Applicant: Tyler & Katie Jenkins

Address: 107 Monument St

CHECK-LIST AGAINST ZONING ORDINANCE  
permit # 2015-01002  
revised siteplan 8-6-15.

Proposed Use/Work - build new 3 story single family home

A2.1

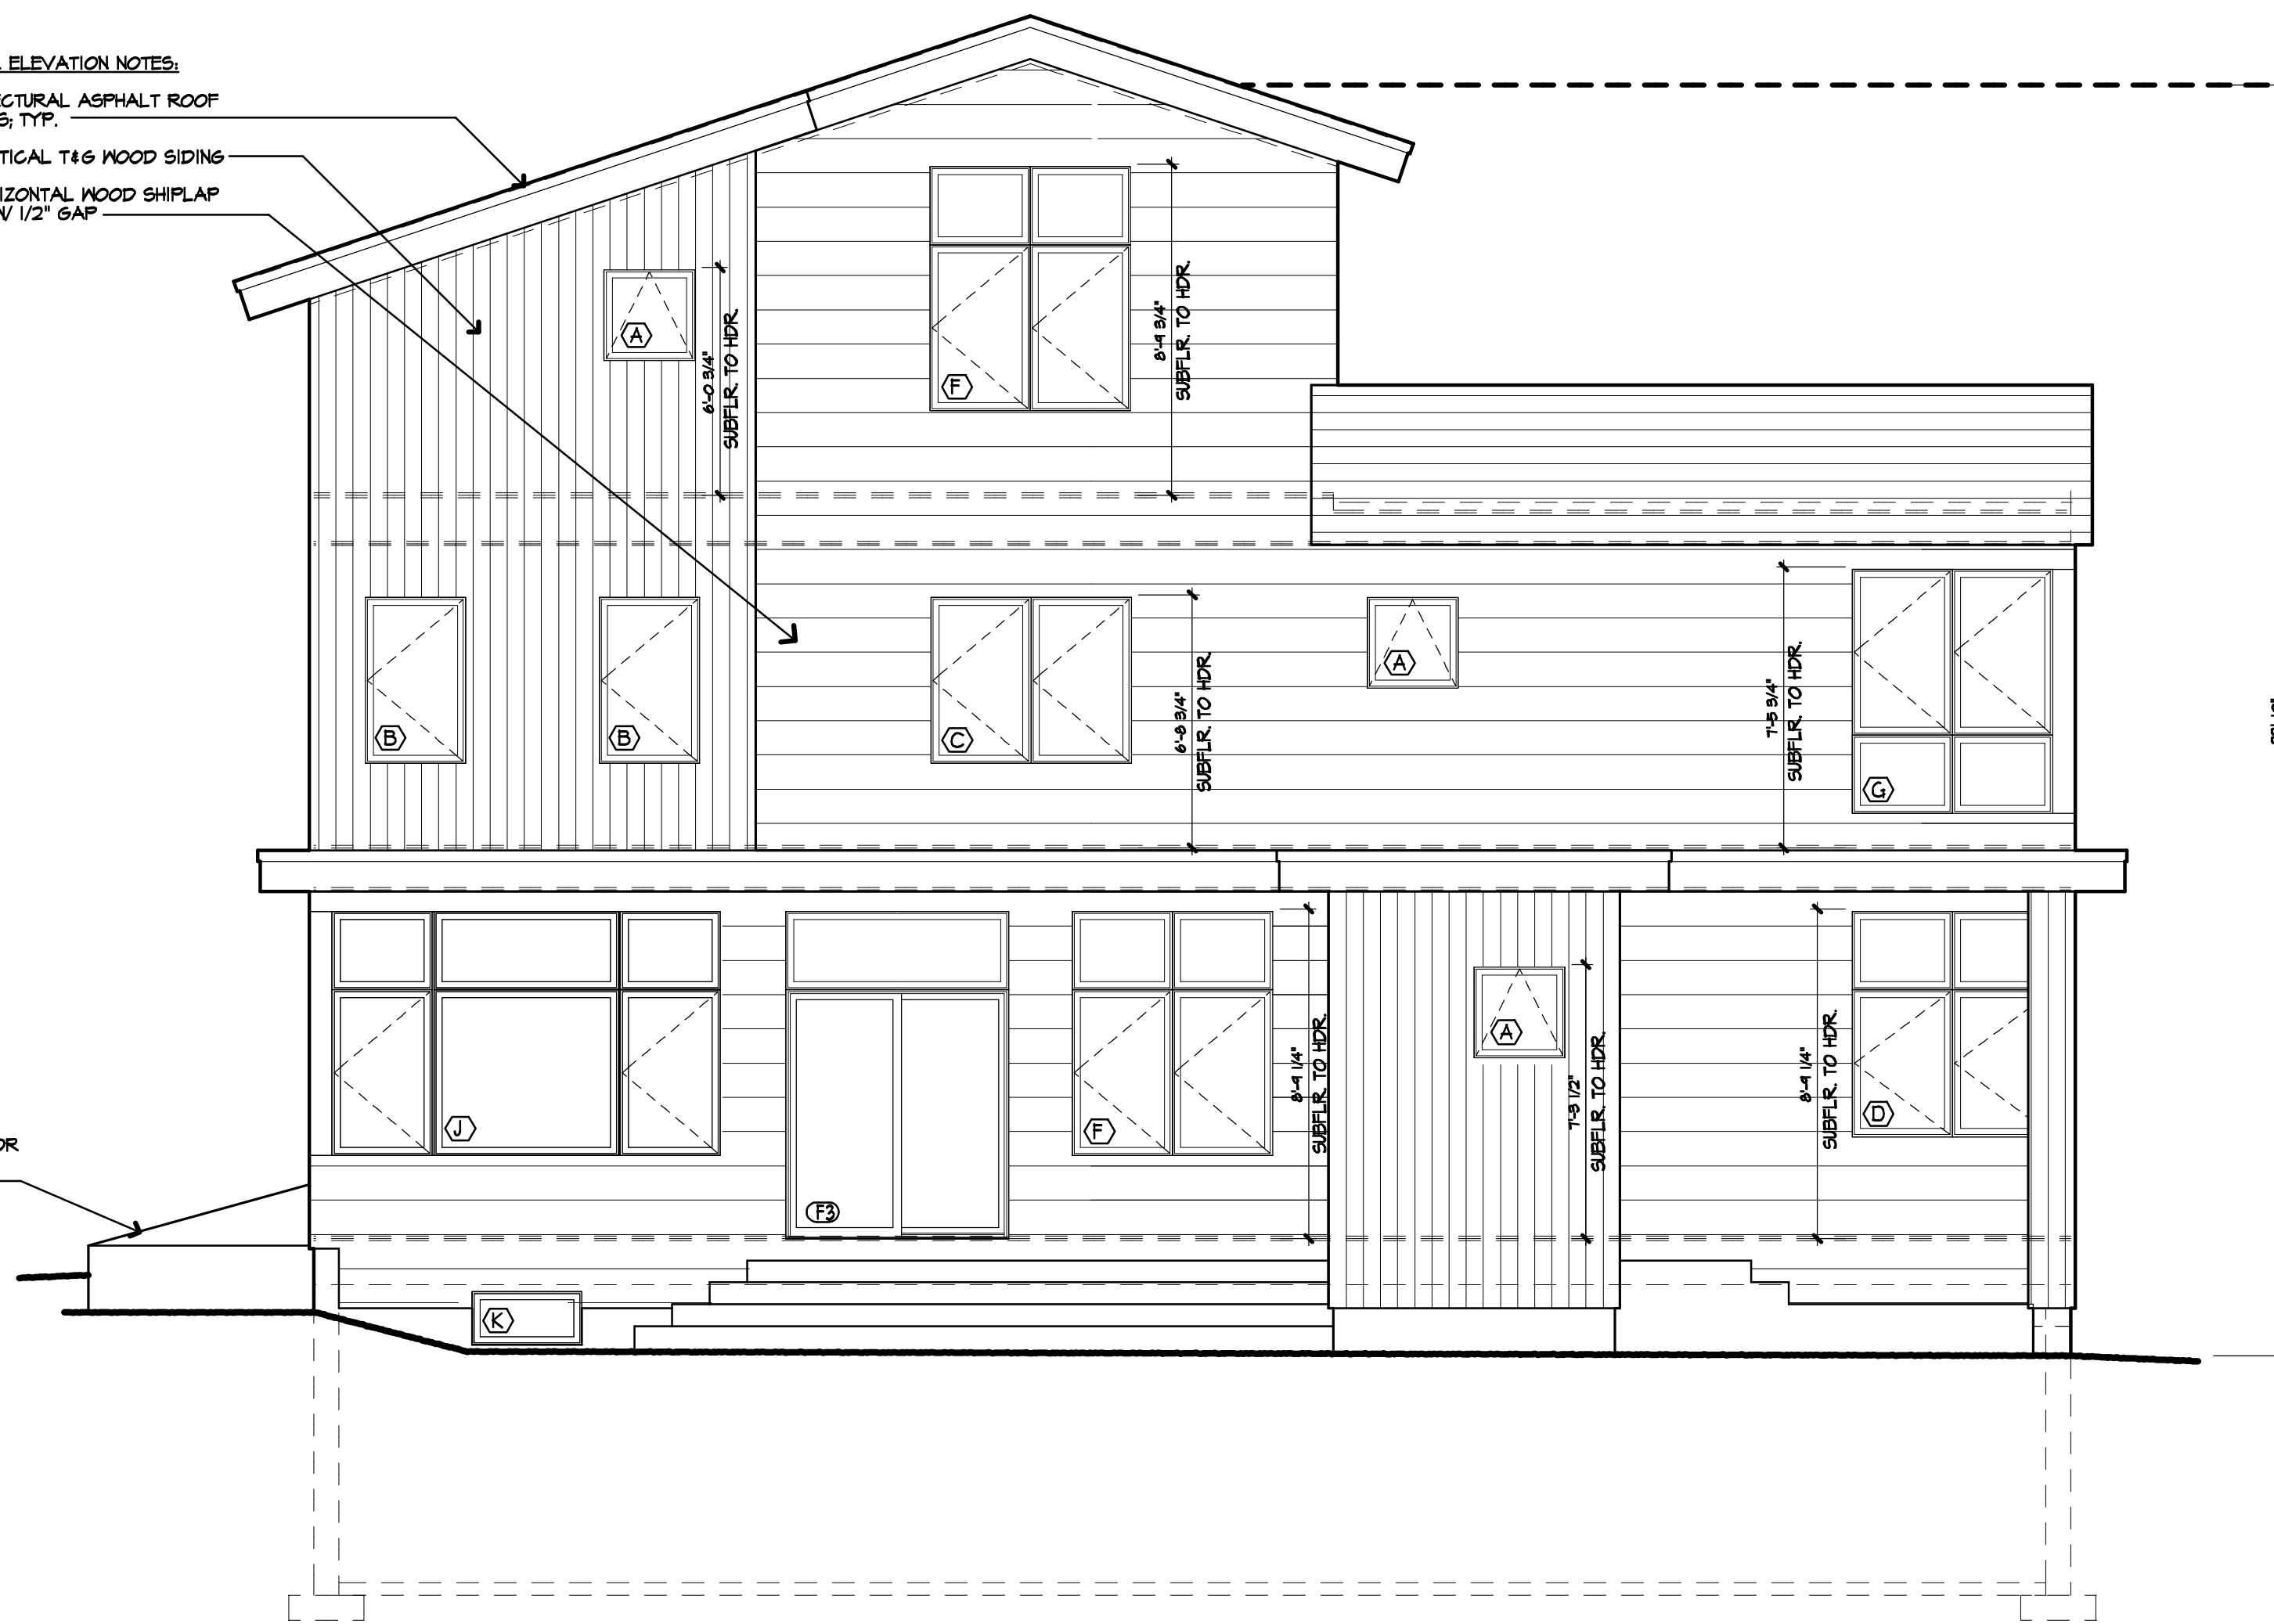
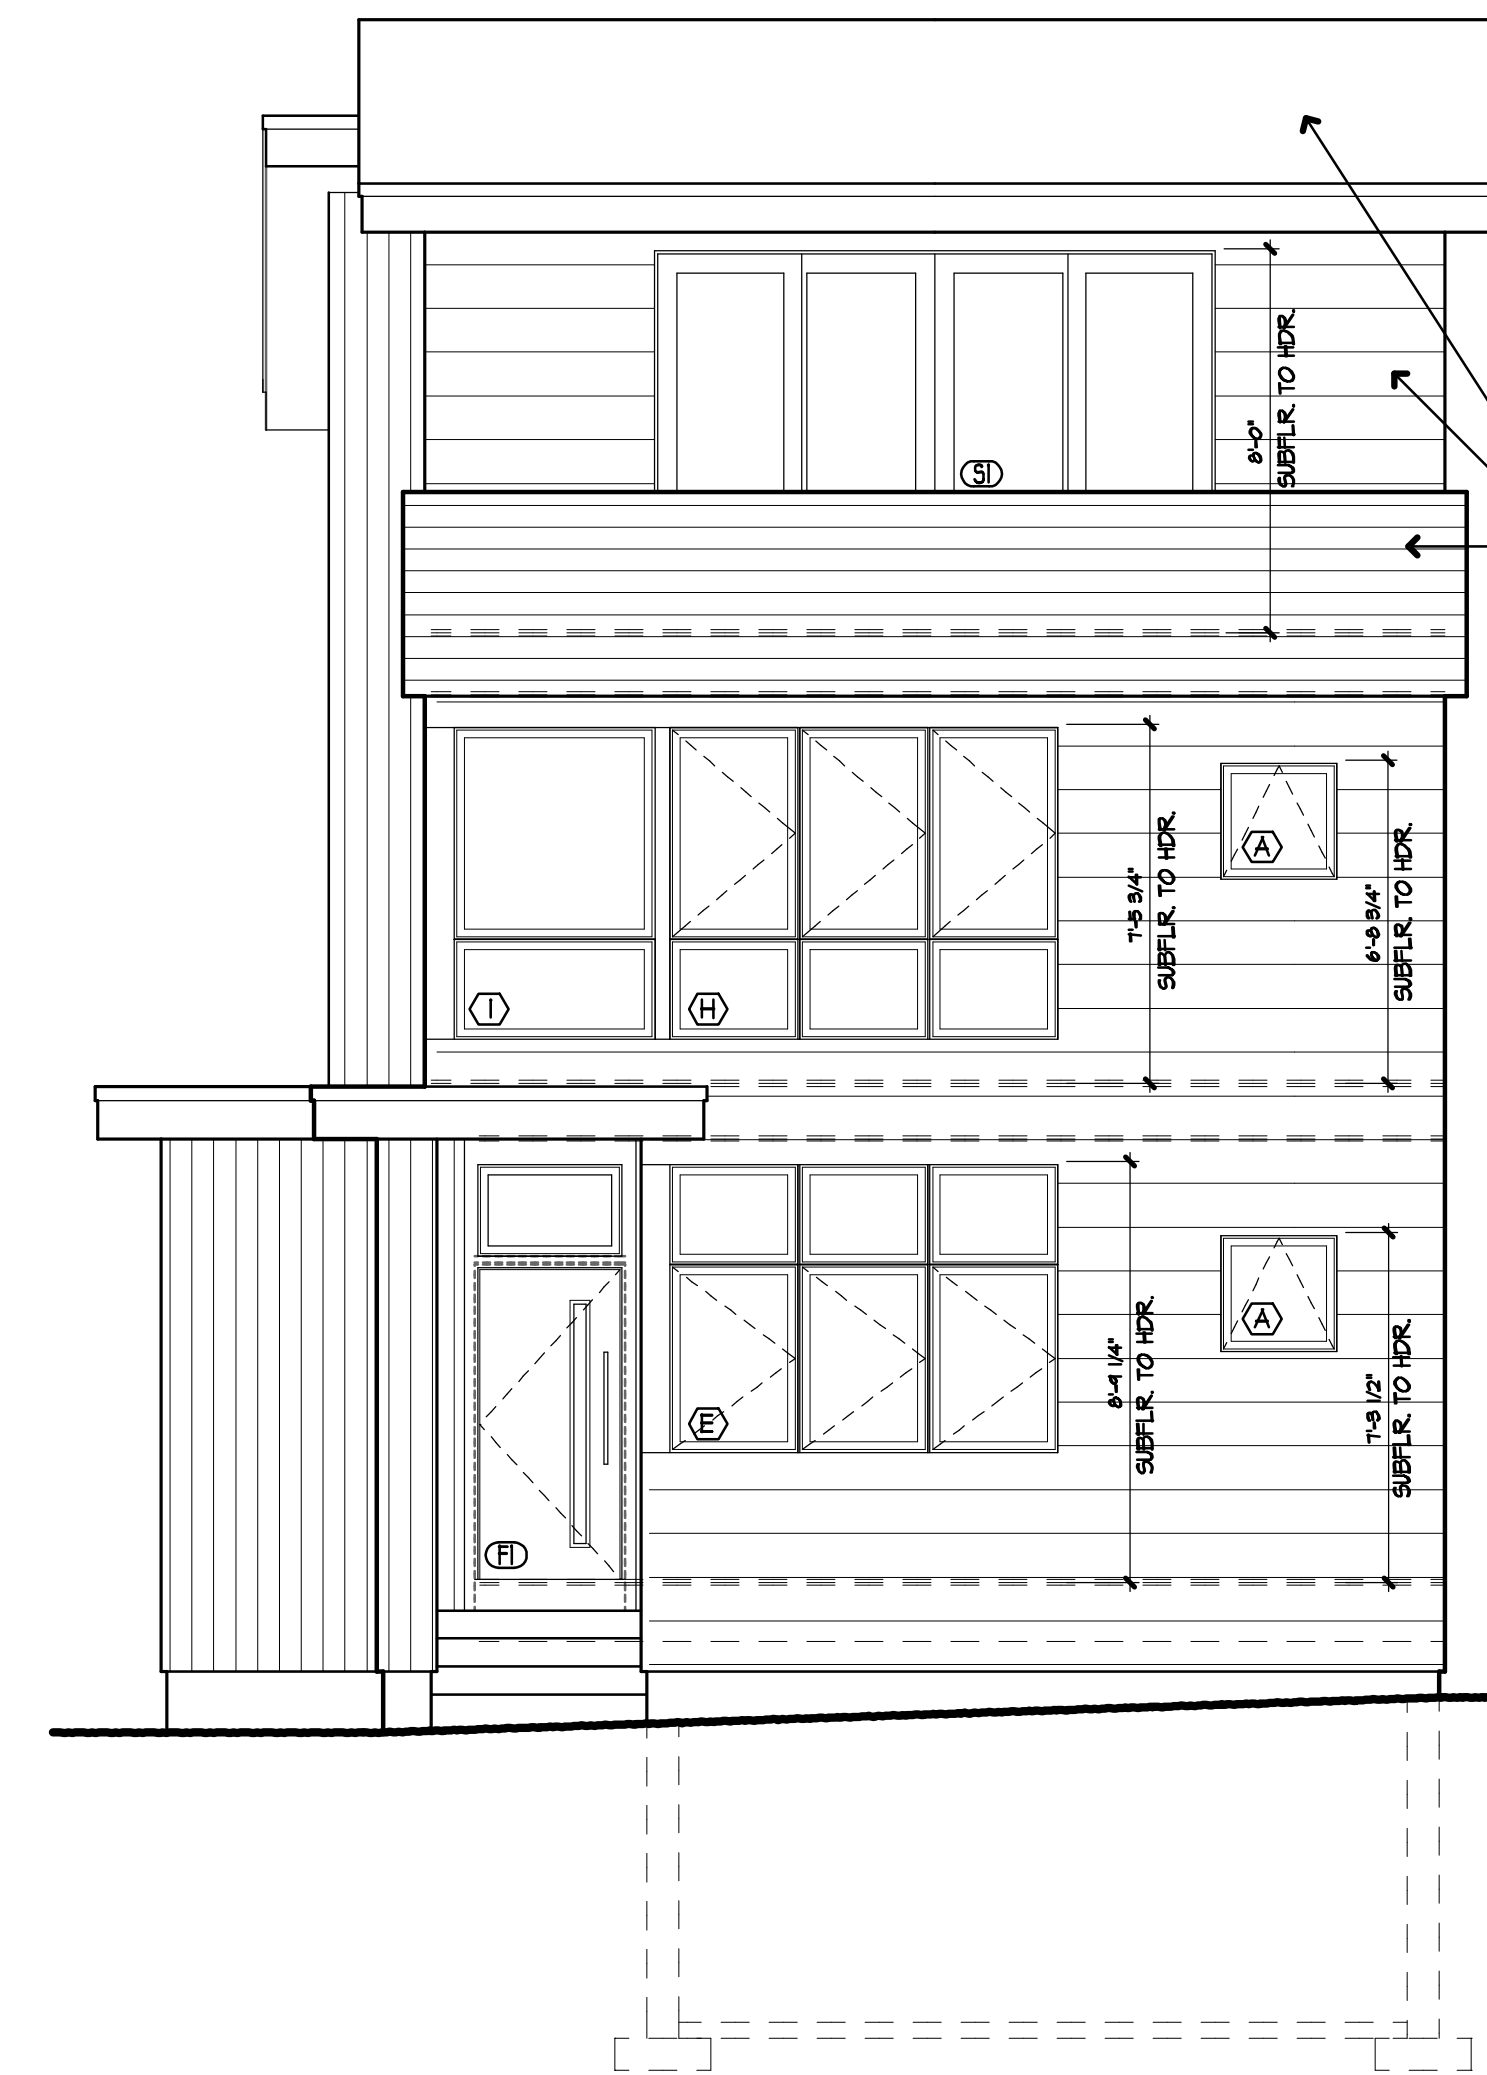
Height - 45' max - height bridge is 35' (OK)

Structure setbacks - no higher than 35' - 10' from side property line - max height is 35' (OK)  
- 15' from rear.
